Arun District Council
Arun Civic Centre
Maltravers Road
Littlehampton
West Sussex BN17 5LF
Planning & Building Control General Enquiries
Tel: (01903) 737756 Fax: (01903) 730442
Dx: 57406 Littlehampton
Minicom: 01903 732765
e-mail: planning@arun.gov.uk
website: www.arun.gov.uk/planning

Town & Country Planning Act 1990 (as amended)
Town & Country Planning (Development Management Procedure) (England) Order 2015

Application No: EP/7/21/HH
Site Address: Little Dormers 23 Upper Drive East Preston BN16 1QN
Description of works: New bay/porch skirt roof to front elevation & single storey front extension to provide additional garaging.

Thank you for your internet representation made on 4th March 2021 which has been recorded as an objection with the comments as follows:

Drawing No Status Revision
203075/ 010

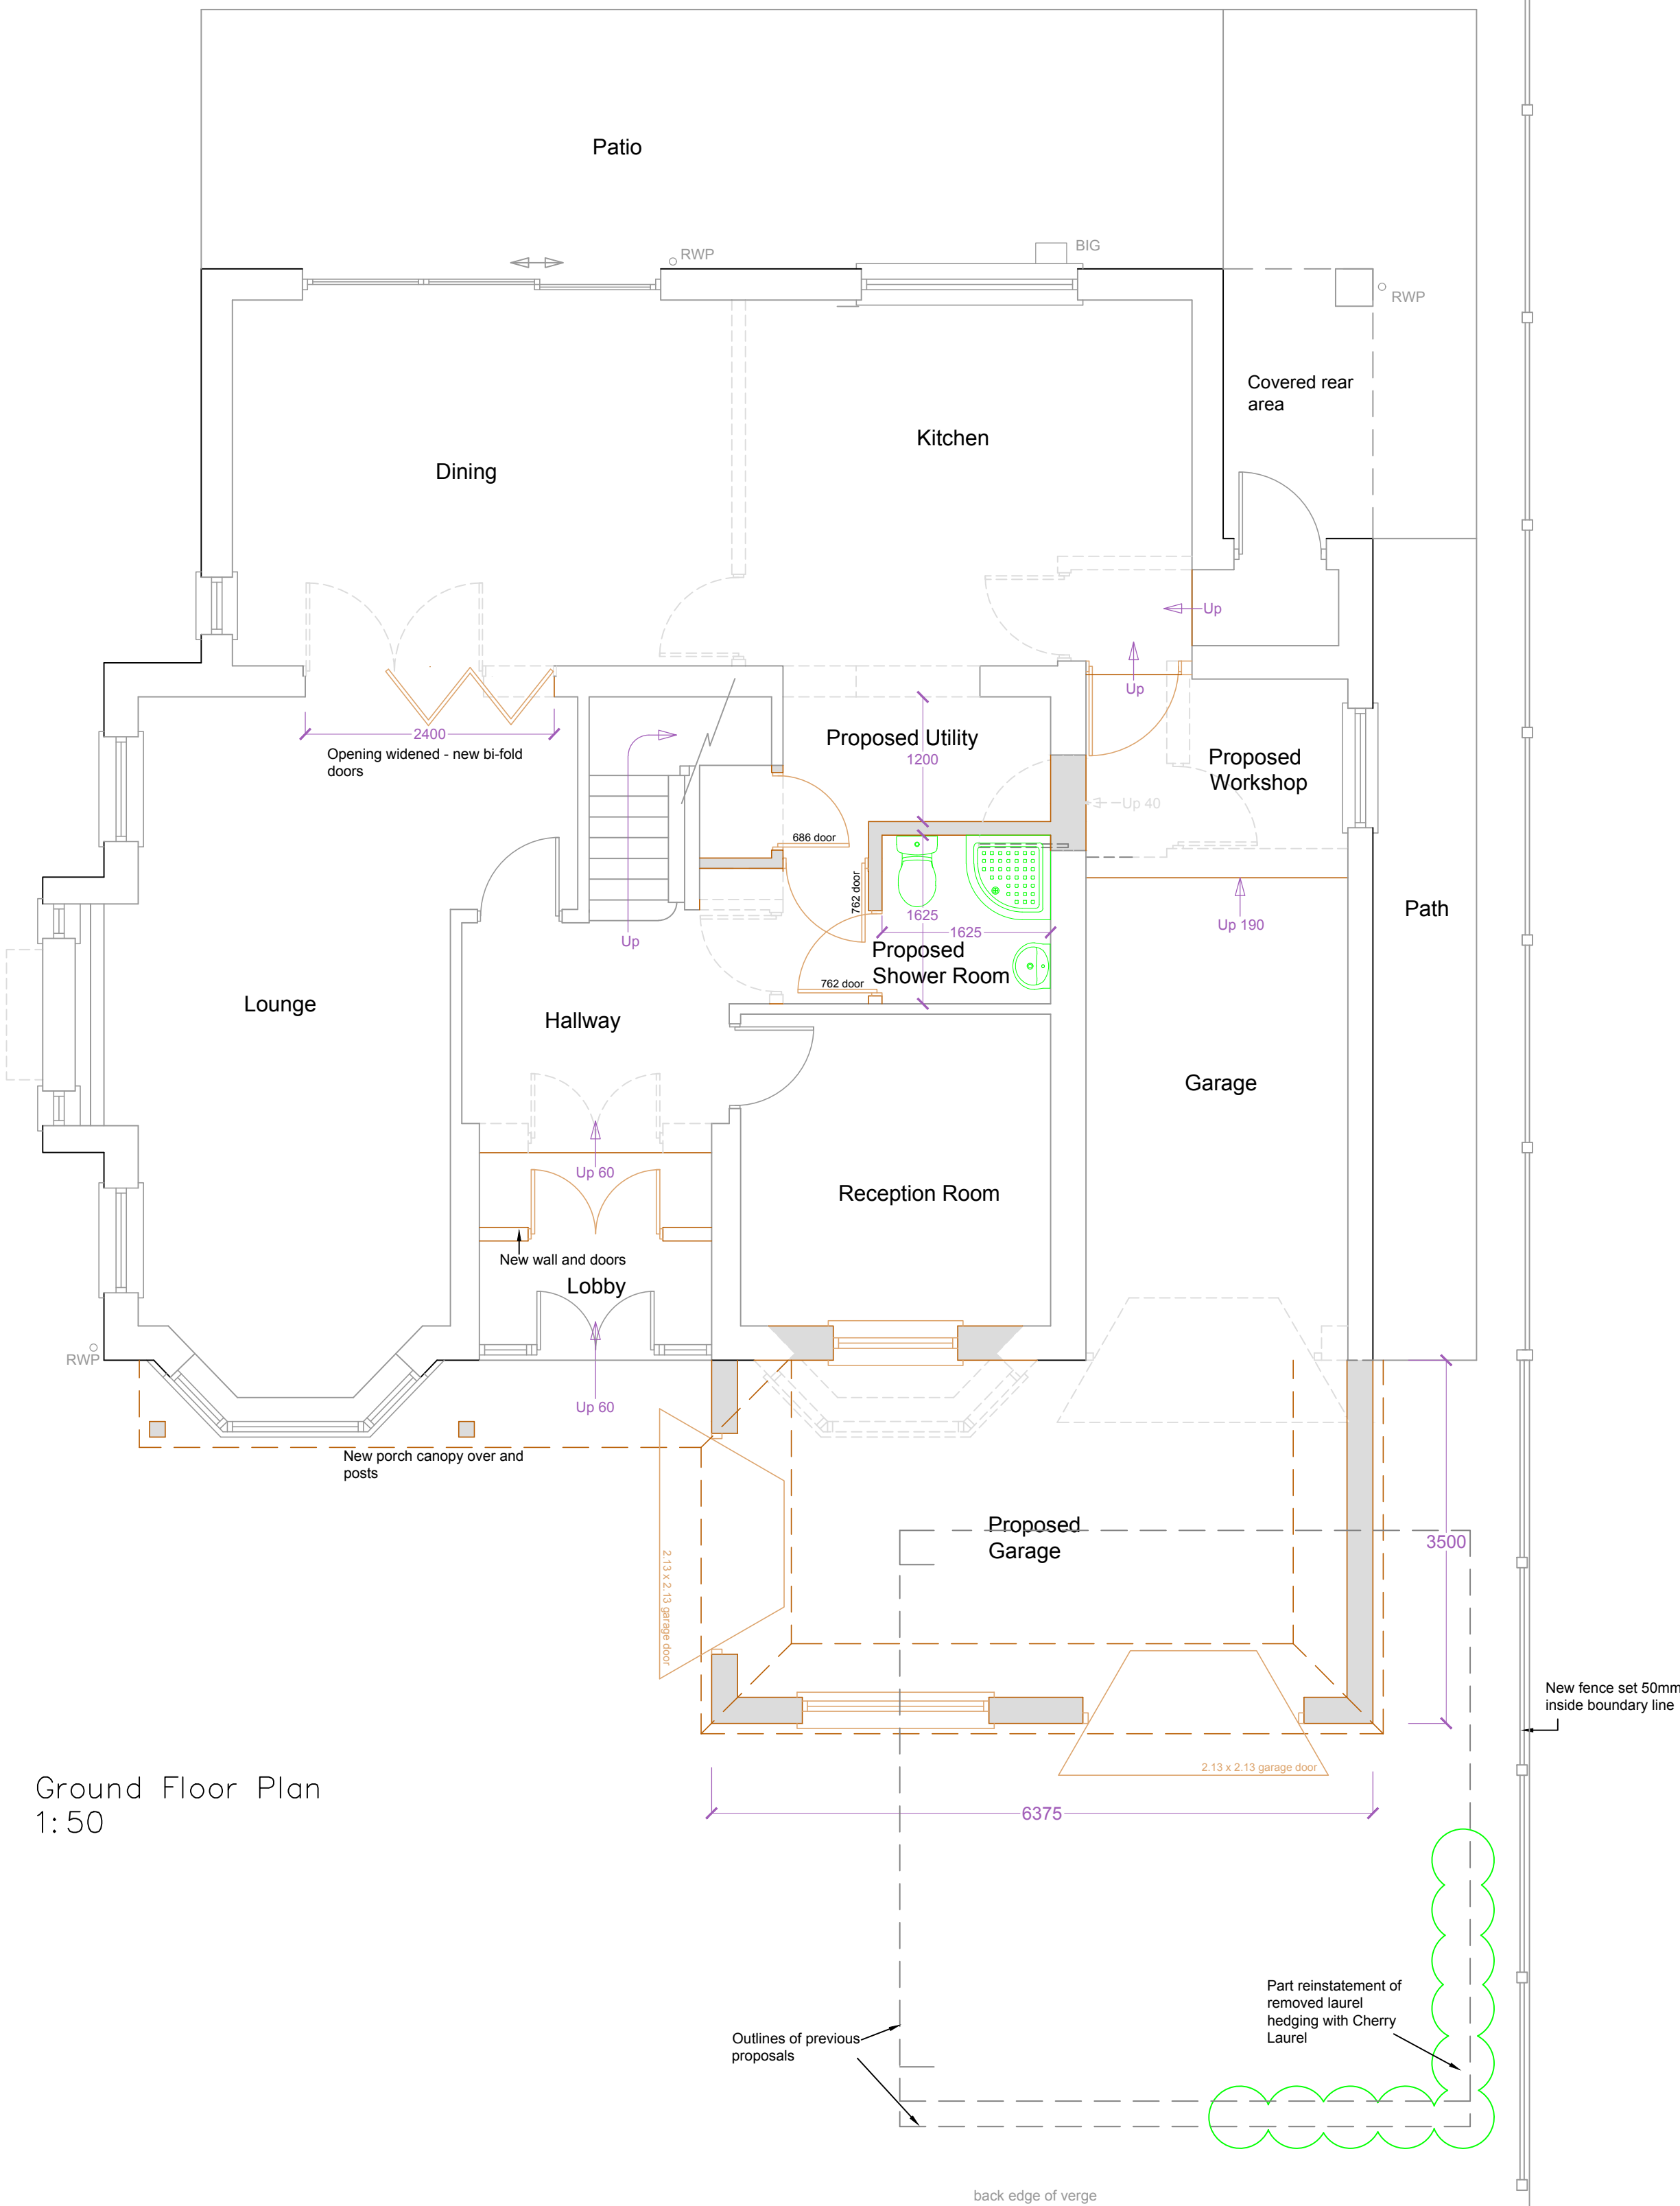
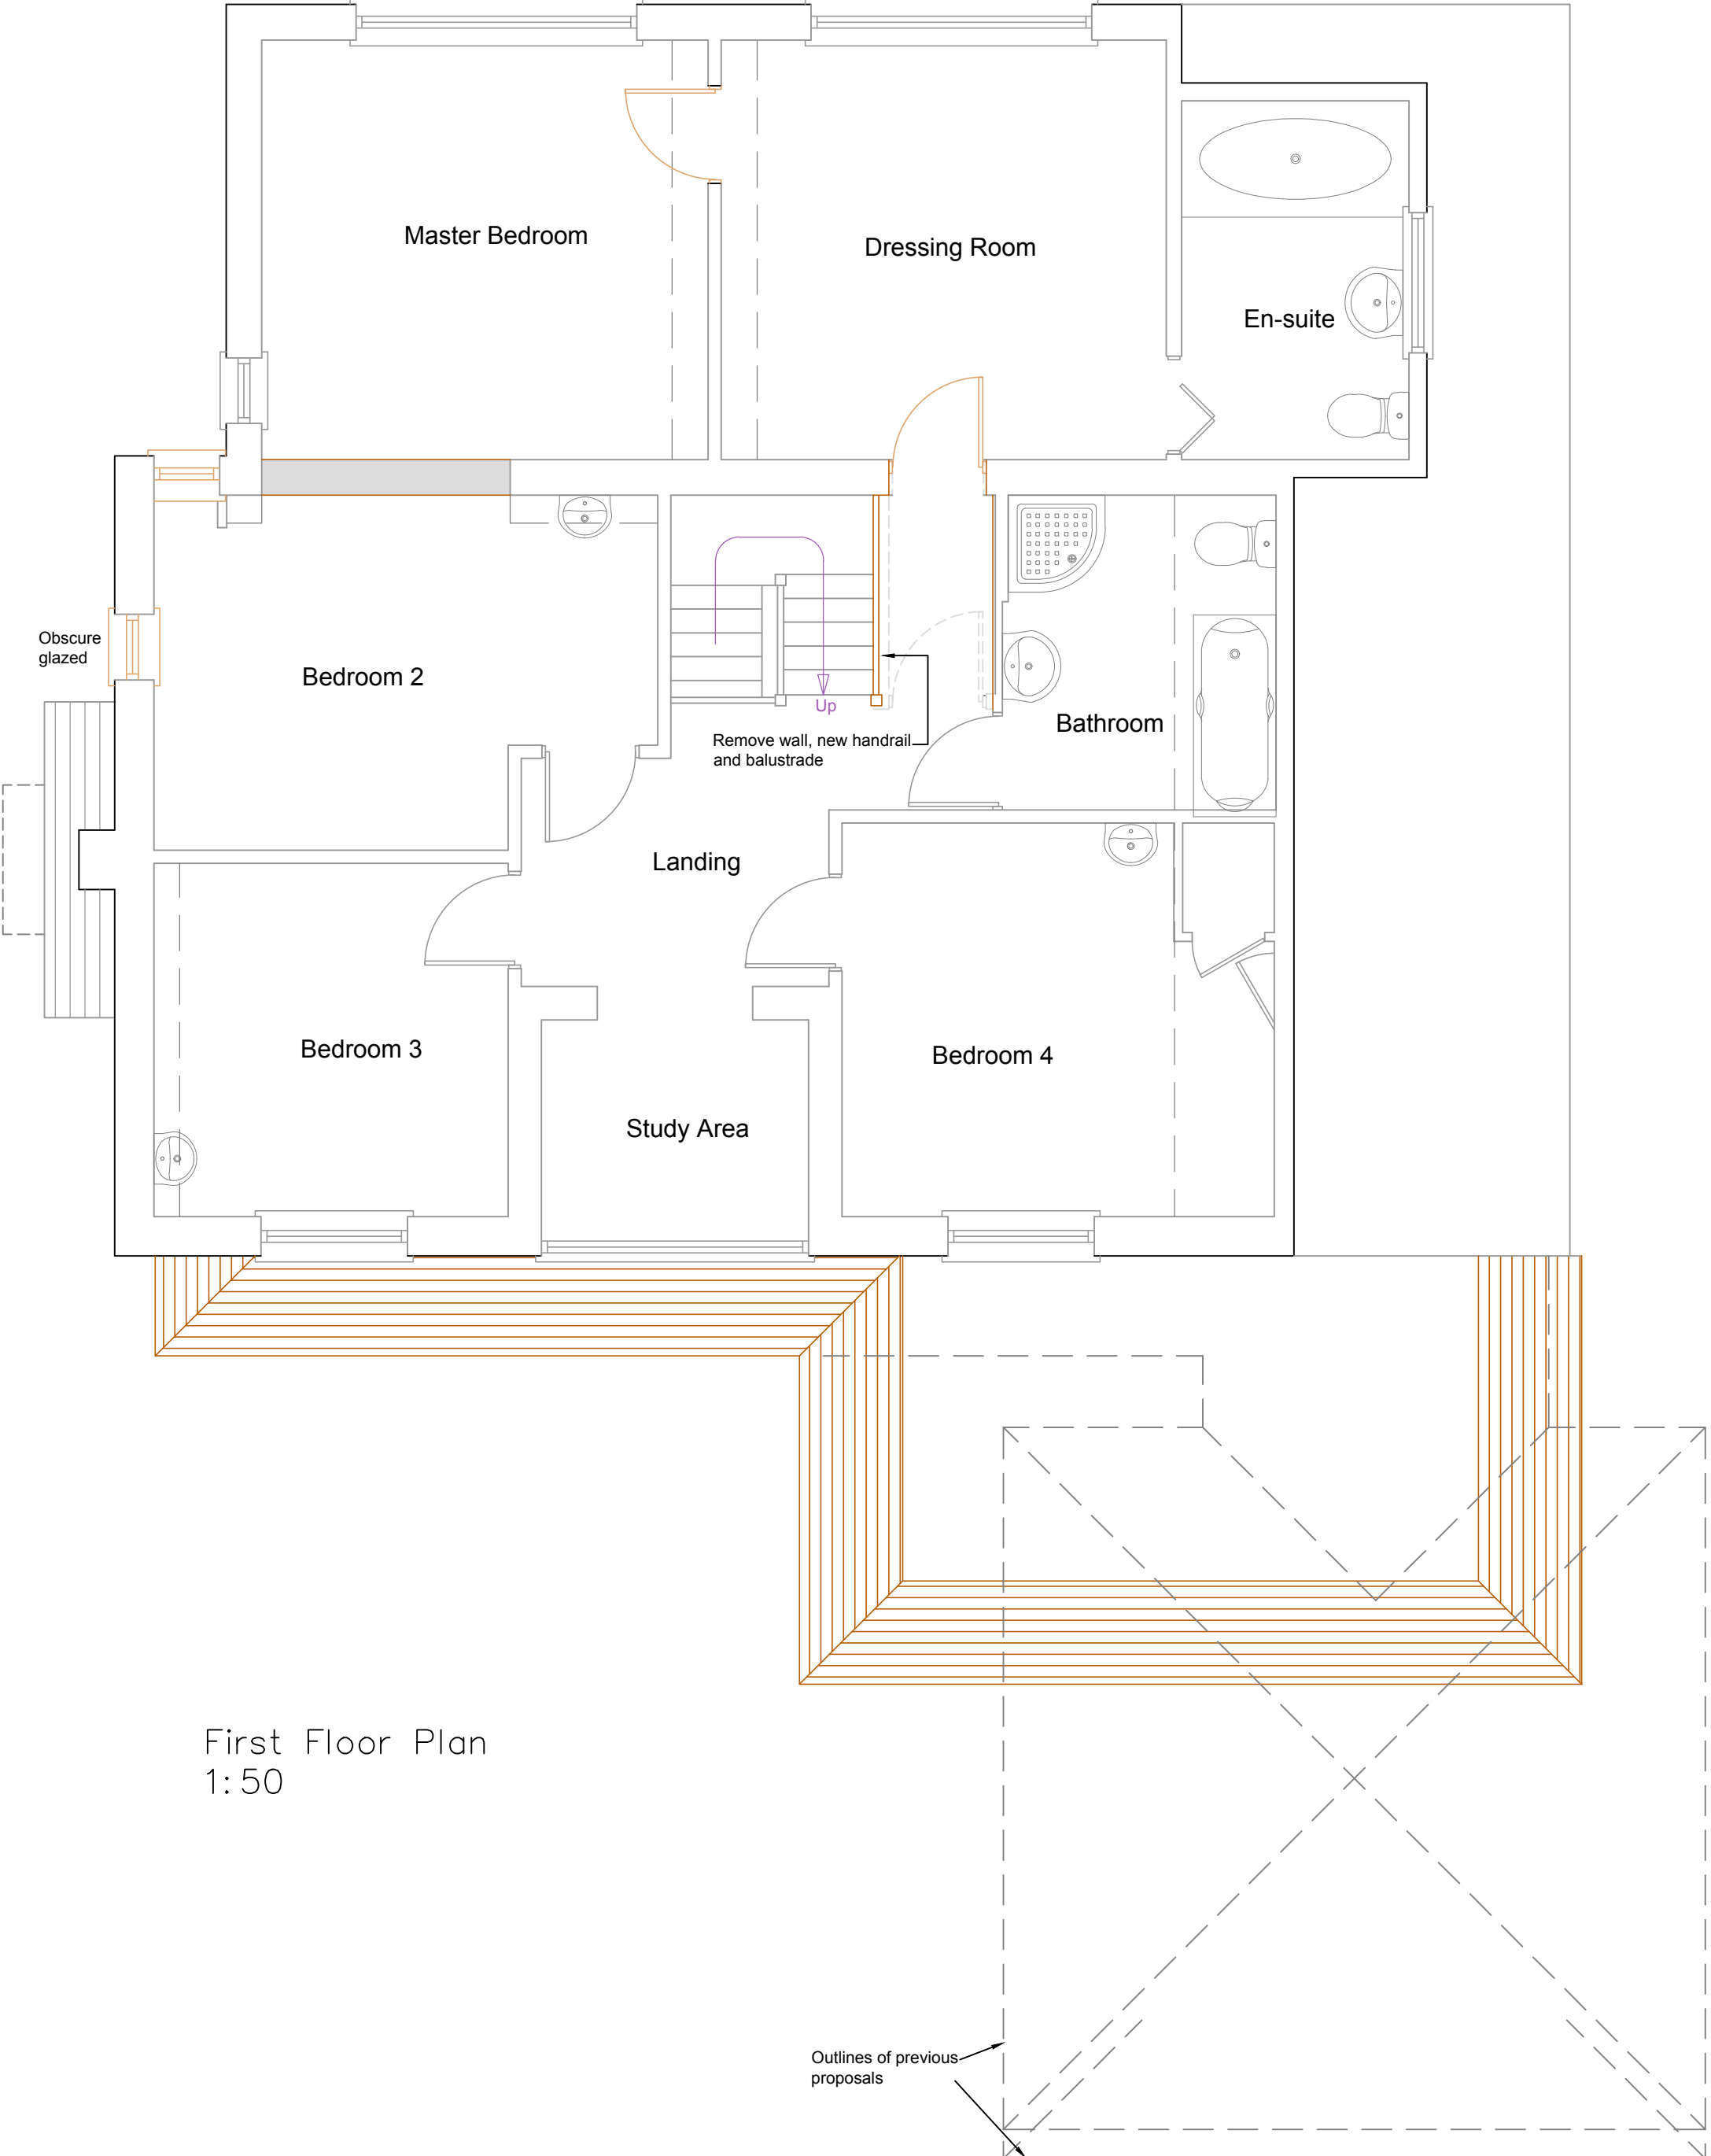
4. The problem of the potential loss of privacy has been created by the applicant. Trees and shrubs have been removed and the applicant wants to change the internal layout of the 23 Upper Drive. The proposed windows are not needed if the applicants planned alterations to the 1st floor living space are not carried out. If the current floor plan as shown in drawing 203075/08 is not changed there is no need for additional windows.

Drawing No Status Revision
203075/ 011

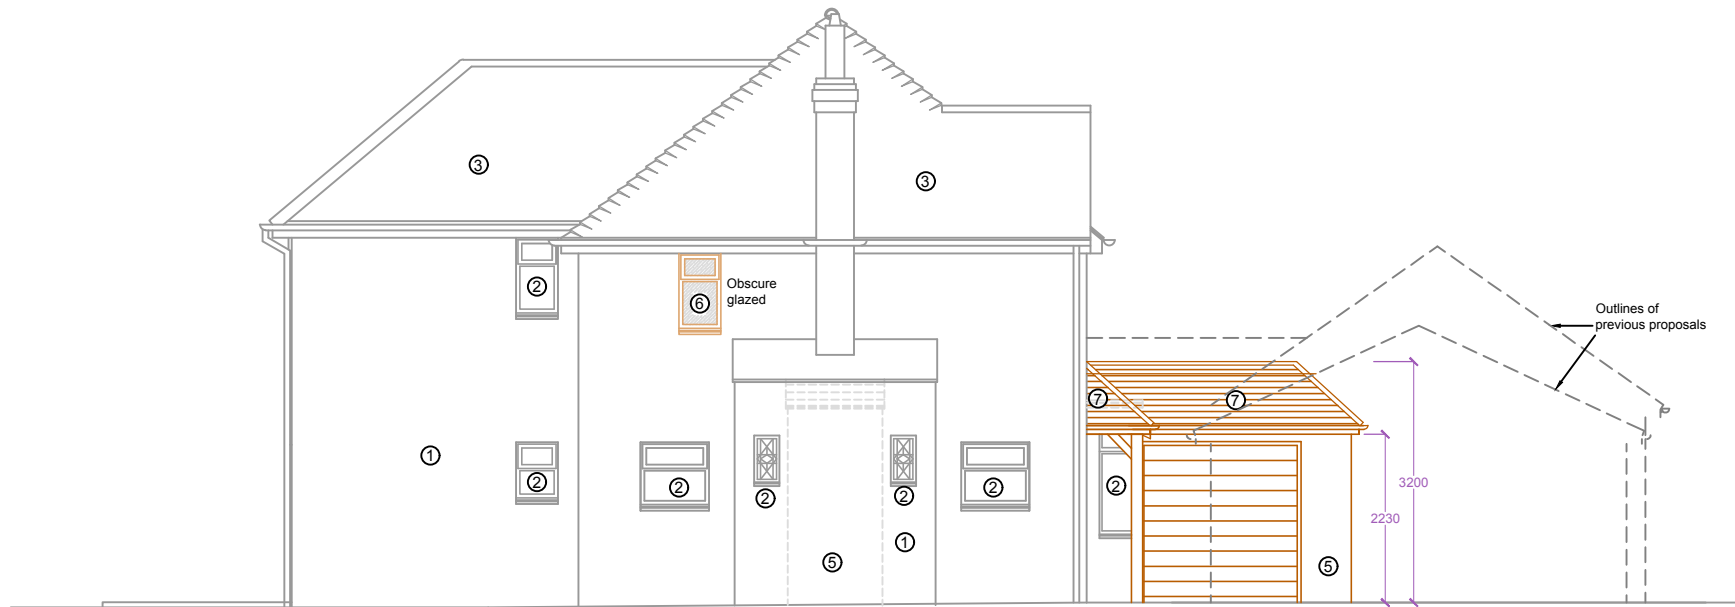
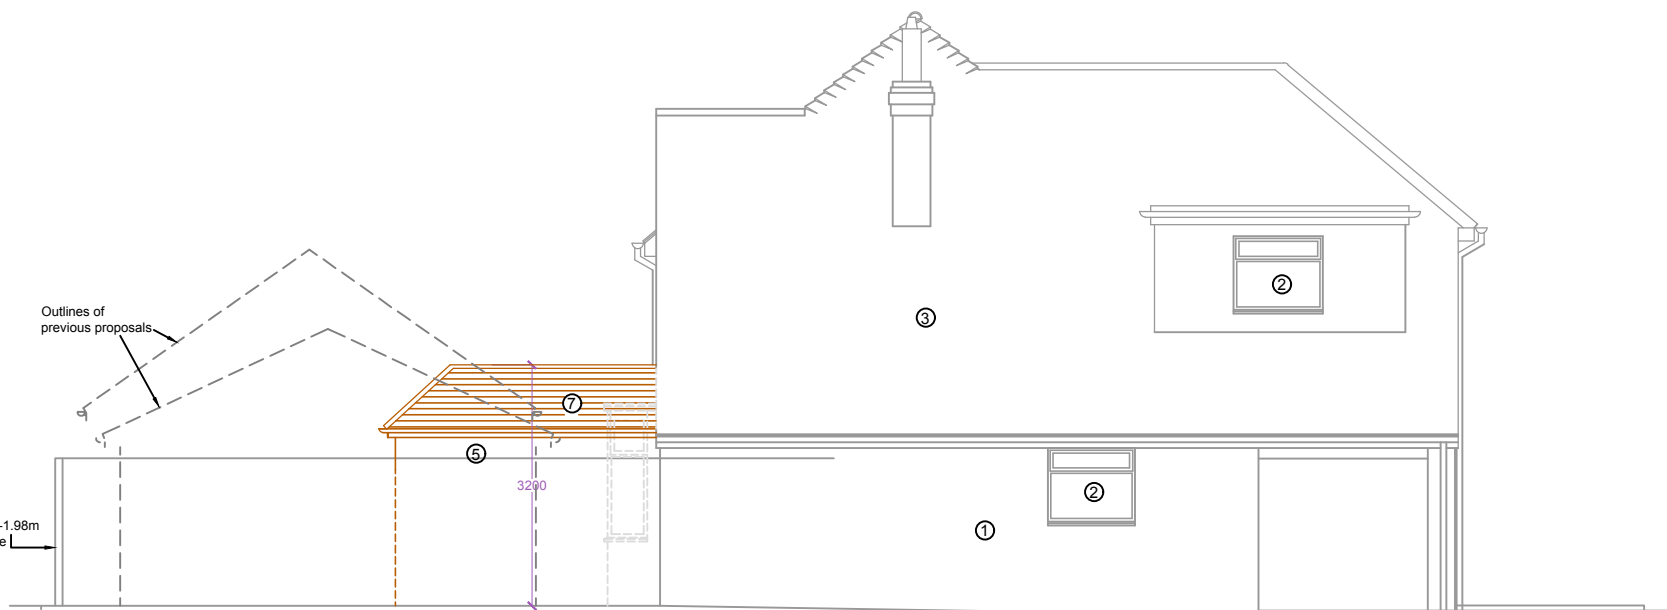
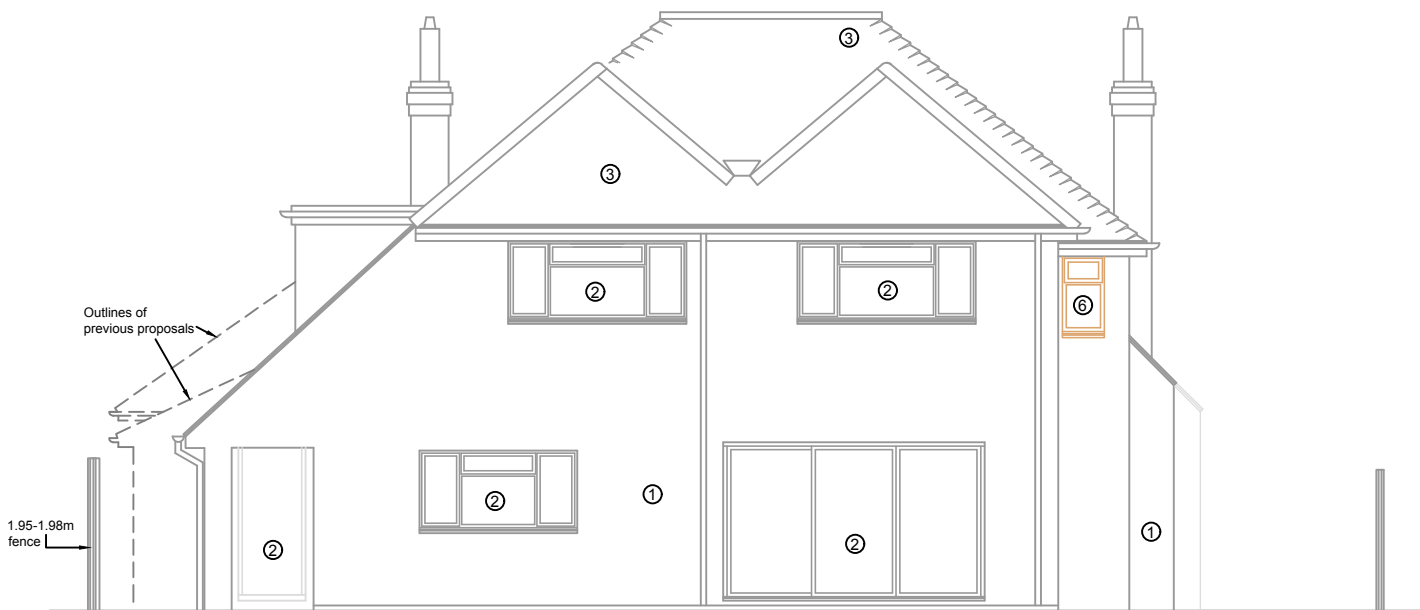
The description of proposed works in planning application EP/7/21/HH does not refer to new windows. However, the plans show proposals to install 2 new windows, both on the (south) side elevation but one angled so it is only visible on the plan showing the west elevation.

The proposed most easterly window will lead to overlooking of the garden and a bedroom of 21 Upper Drive and the garden and living space of 59 Manor Road.

The proposed most westerly window will lead to overlooking of the garden and living space of 59 Manor Road from a different angle. As a result the applicant will have a view of the whole of the back garden and living space of 59 Manor Road.

Plan drawing 203075/011 shows obscure glass for the proposed most easterly window but obscure glass doesn't stop overlooking, it just means the image is distorted or blurry. Also, the glass can be changed at any time by the current or future occupants.

The proposed windows will lead to overlooking of neighbouring properties, in particular 21 Upper Drive and 59 Manor Road.

The plans for 23 Upper Drive do not include any additional design measures or landscape screening (in fact the landscape screening has been removed). In order for the proposed windows to be in accordance with The Design Guide other initiatives would be required.
